City of Portland, Maine - Building or Use Permit Application
 389 Congress Street, 04101 Tel: (207) 874-8703, Fax: (207) 874-8716

Permit No: 06-0531	Issue Date:	CBL: 038 F009001
------------------------------	--------------------	----------------------------

Past Use: Commercial - Portland Harbor Hotel	Proposed Use: Commercial replace 1 wall sign & add 1 projecting sign, both internally illuminated (both incidental)	Permit Fee: \$97.00	Cost of Work: \$97.00	CEO District: 1
		FIRE DEPT: <input type="checkbox"/> Approved <input type="checkbox"/> Denied		INSPECTION: Use Group: Type
Proposed Project Description: Replace 1 wall sign (on Union St.) & add 1 projecting sign on Fore St. (both internally illuminated & incidental)		Signature:		Signature:
		PEDESTRIAN ACTIVITIES DISTRICT (P.A.D.) Action <input type="checkbox"/> Approved <input type="checkbox"/> Approved w/Condition <input type="checkbox"/> Denied Signature: Date:

**ITEM C D/F ILLUMINATED PROJECTING SIGN**  
 SCALE: 1/2" = 1'-0"

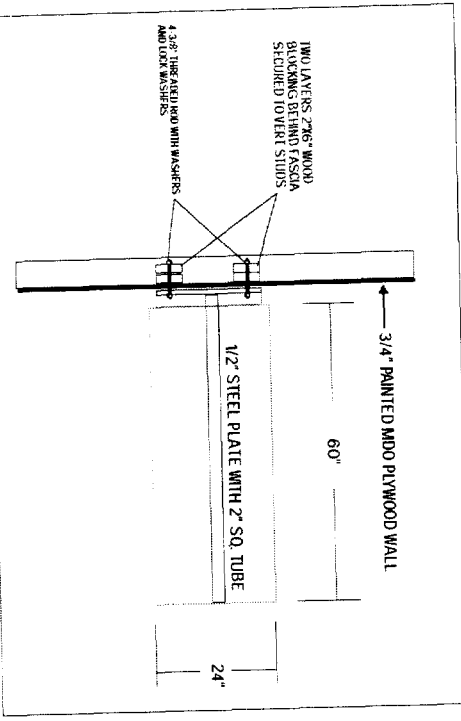
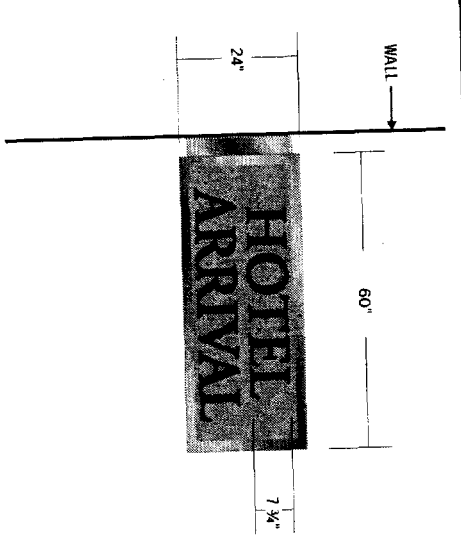
6/27/2006-mjn: left message w/Barlo sign, the overhanging sign appears to exceed the limitations of Sectionb 3202.3.1 of the building code. Will also want some engineering.

1) The overhanging sign has been reduced to 60 inches to comply w/ Building Code.
